February 26, 2015

Project Name: The Forefront at Thompson's Point Level II Site Plan  
Application  
Project ID: PEZ 2015-021  
Address: 1 Thompson's Point CBL: 201 A005  
Applicant: Chris Thompson, Forefront Partners I, LP  
Planner: Christine Grimando

**To:** FILE  
**From:** Christine Grimando  
**Subject:** Application ID: 2015-021  
**Date:** 2/26/2015

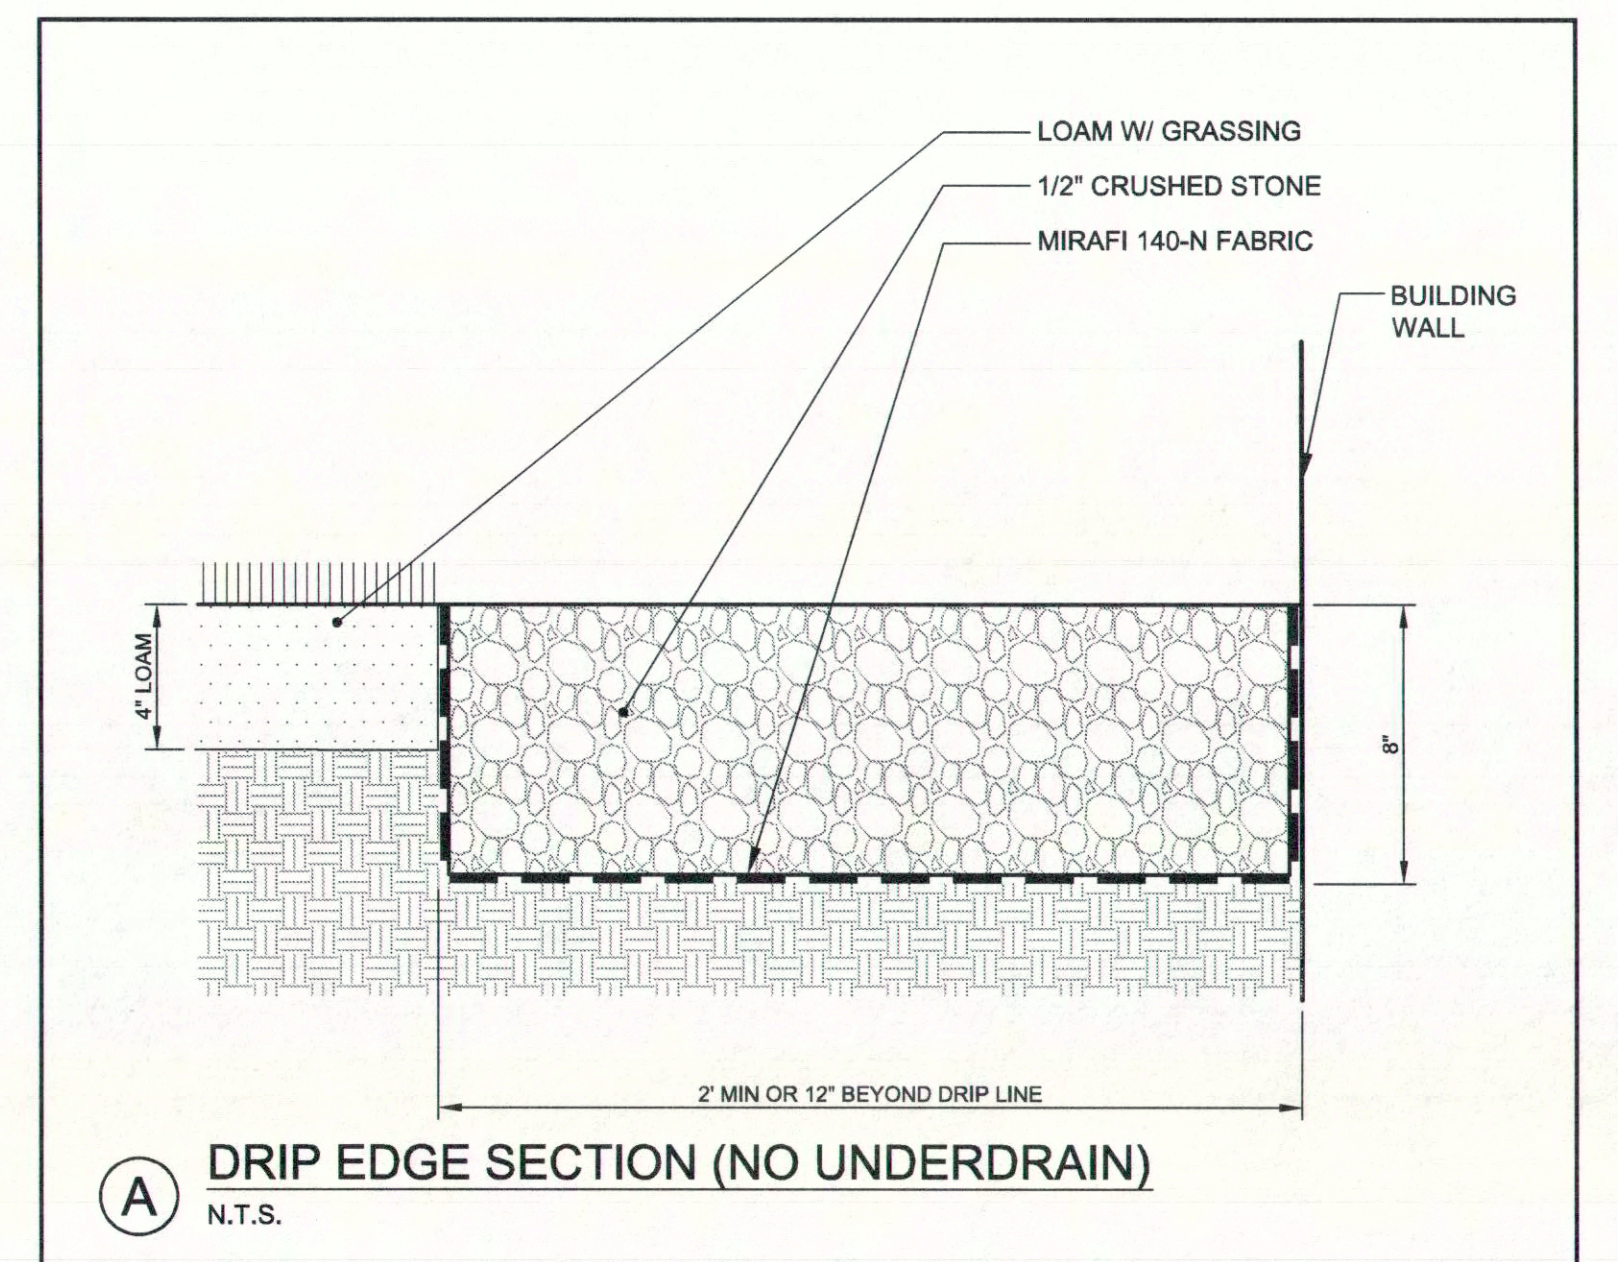
1. The final plan set, Sheet C-1.0 Event Area Re-Surfacing Site Layout and Grading Plan, shall include the following:
  - The contractor shall install, maintain and monitor all Erosion and Sediment Control devices in strict accordance with the City of Portland technical requirements and the MaineDEP Best Management Practices (BMP) Manual.
  - All erosion and sediment control measures shall be installed prior to any land disturbance as shown on these plans.
2. The proposed site disturbance is being completed to facilitate the use of the site for special events through the 2015 season, while plans for the property are being prepared in conformance with the approved Master Development Plan. Hosting of special events at the site beyond the 2015 season shall be approved by the Planning Authority in writing.

The plan will need to include the following:

Erosion Control Notes:

1. This project is directly tributary to the Fore River. The contractor shall install, maintain and monitor all Erosion and Sediment Control devices in strict accordance with the City of Portland technical requirements and the MaineDEP Best Management Practices (BMP) Manual.
2. All erosion and sediment control measures shall be installed prior to any land disturbance as shown on these plans.
